**M54 to M6 Link Road**

**8.8 O(D) Draft Statement of Common  
Ground with Staffordshire Wildlife Trust**

<b>Version</b>	<b>Date</b>	<b>Status of Version</b>
5 (P07)	12 February 2021	Issue to the ExA for Deadline 6

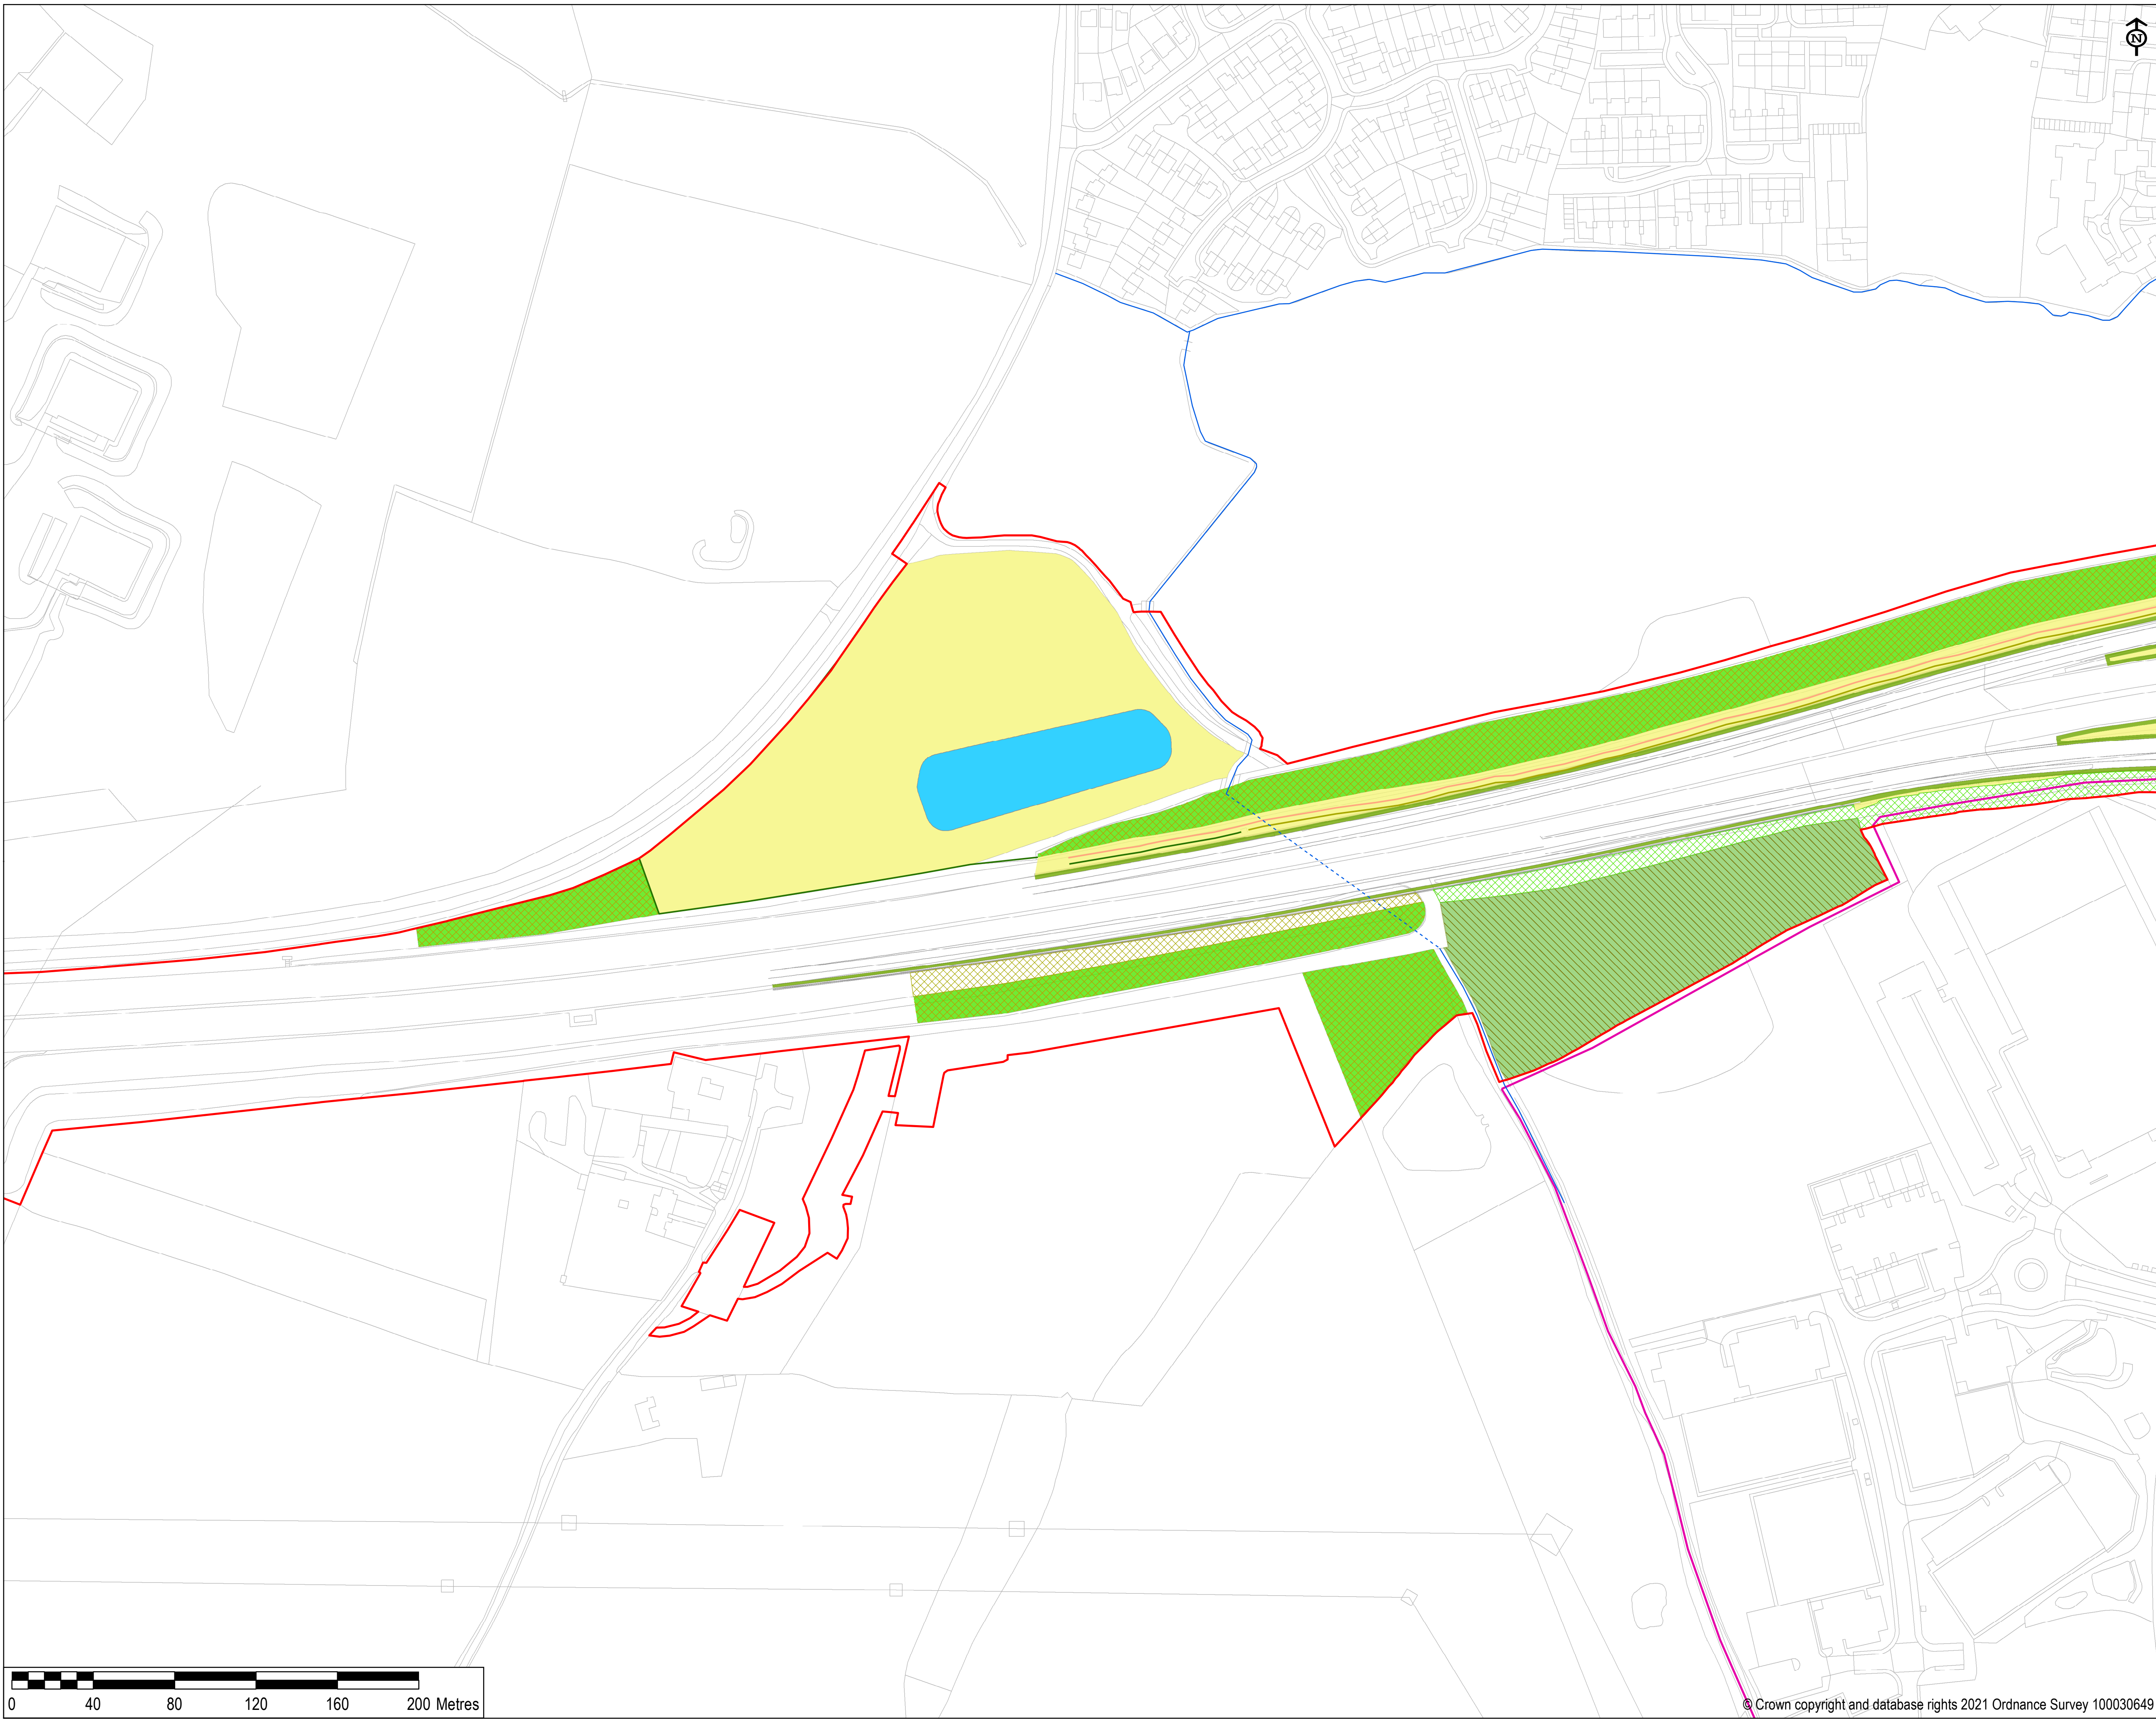
Habitat restoration RR-042n	Section 8.8 'Design, mitigation and enhancement'	Ancient woodland and Veteran Trees within Brookfields Farm SBI – 0.0015 ha direct loss; 0.04ha assumed loss due to incursion into the 15 m buffer zone and a further 0.078 ha assumed lost as a result of the change in air quality. Provision of 3.08 ha of broad-leaved plantation (7:1 ratio) has been agreed with Natural England. Direct losses should be avoided by amending the road embankment to a retaining wall adjacent the site.  Following discussions at the meeting held on the 11 November, SWT agree that the revised Scheme alignment does avoid the direct loss of ancient woodland.	Existing areas of ancient woodland for retention and enhancement, are shown on Figure 2.3 Environmental Masterplan Sheet 1 of 5 [AS-088/6.2]	Agreed	Agreed	Agreed

Issue	Sub-section of the ES	Staffordshire Wildlife Trust Comment	Highways England Response	Status	Agreement likely (App)? <sup>1</sup>	Agreement likely (IP)?
			<p>for Brookfield Farm SBI and LWS; and Figure 2.6 Sheet 4 of 5 [AS-088/6.2] and Figure 2.7 Sheet 5 of 5 [AS-088/6.2] for Oxden Leasow (Whitgreaves Wood).</p> <p>General enhancement measures for woodland are included within the OEMP [APP-218/ 6.11 and subsequent revisions]. Table 3.4 ref D-BIO10 states that 'Timber from felled trees shall be used for the creation of deadwood areas within selected areas of retained habitat for saproxylic (dead wood loving) species, with some placed in the understory of woodland blocks to enhance woodlands. Felled trees would be retained on site as whole boughs and trunks. These sorts of habitat enhancements are not shown within the biodiversity metric calculation as they may not necessarily lead to a favourable change in the condition (in terms of the metric) of the habitat being enhanced.</p> <p>Sections of retained watercourses (exact locations to be determined during the detailed design stage) will be enhanced, which would result in a 2.23% gain in biodiversity units using the river metric.</p>
